From: Phill Russell [redacted]
Sent: 12 February 2019 10:54
To: Charlotte Easton
Subject: Re: AW/363/18/T - 20 The Oaks, Aldwick

We have now received the comments from the Tree Officer on your submitted application AW/363/18/T and having received these comment your application is currently set to be refused. I have attached the Arboriculturist's comments, he has however provided advisory comments:

## 19 The Oaks. Application to prune Oak tree overhanging from No20 The Oaks

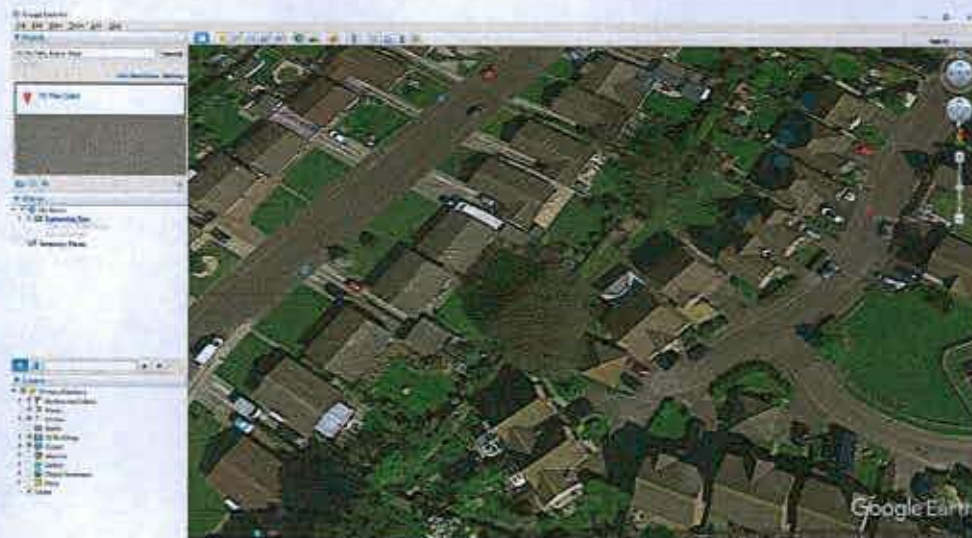
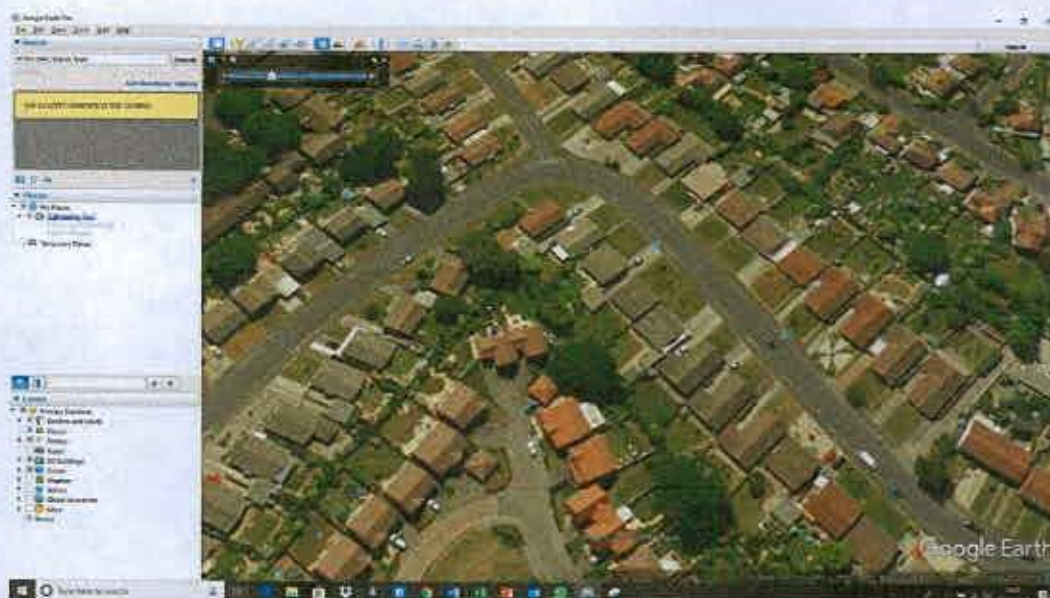
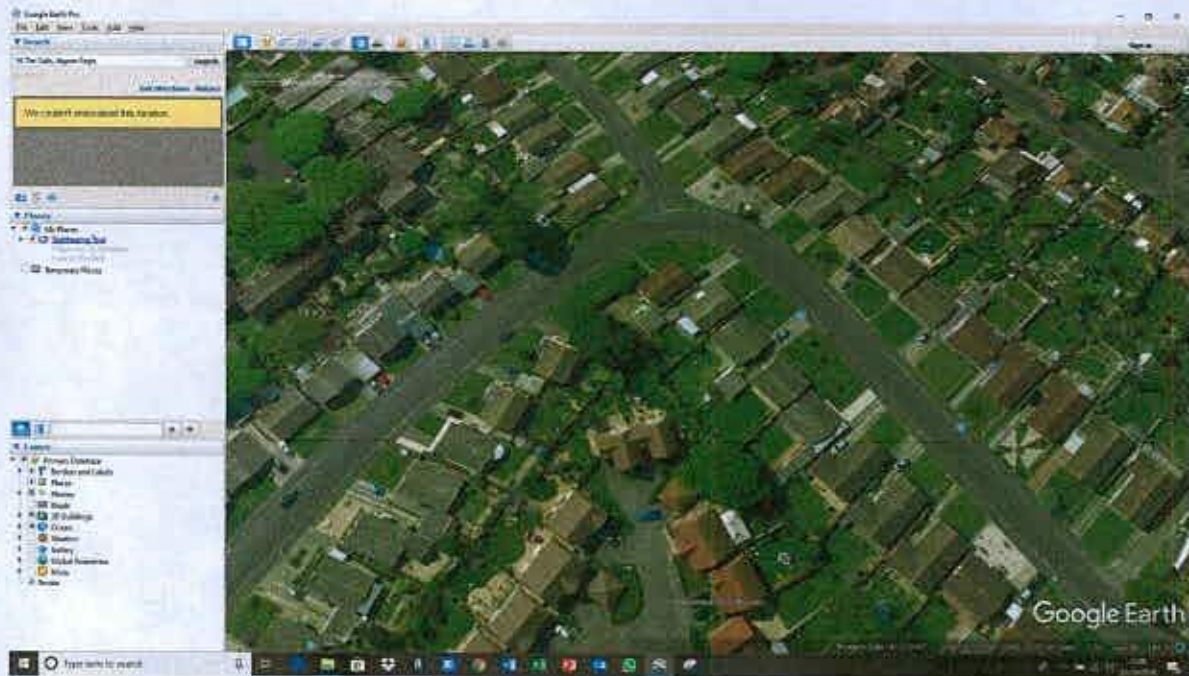
I would like to see the applicant submit a revised specification seeking lesser work, such as detailed below, which would seem to address their concerns whilst preventing a diminution of the tree's landscape and public amenity value:

- Reduce back branches on south aspect to clear residential building (at 19 The Oaks) by maximum of 3metres.***
- Remove low branches as necessary (crown lift) to achieve maximum 3metres overhead clearance above property.***

Thanks for the response and the revised proposals are acceptable.
Would you be kind enough to let me know when a decision will be confirmed.
Many thanks
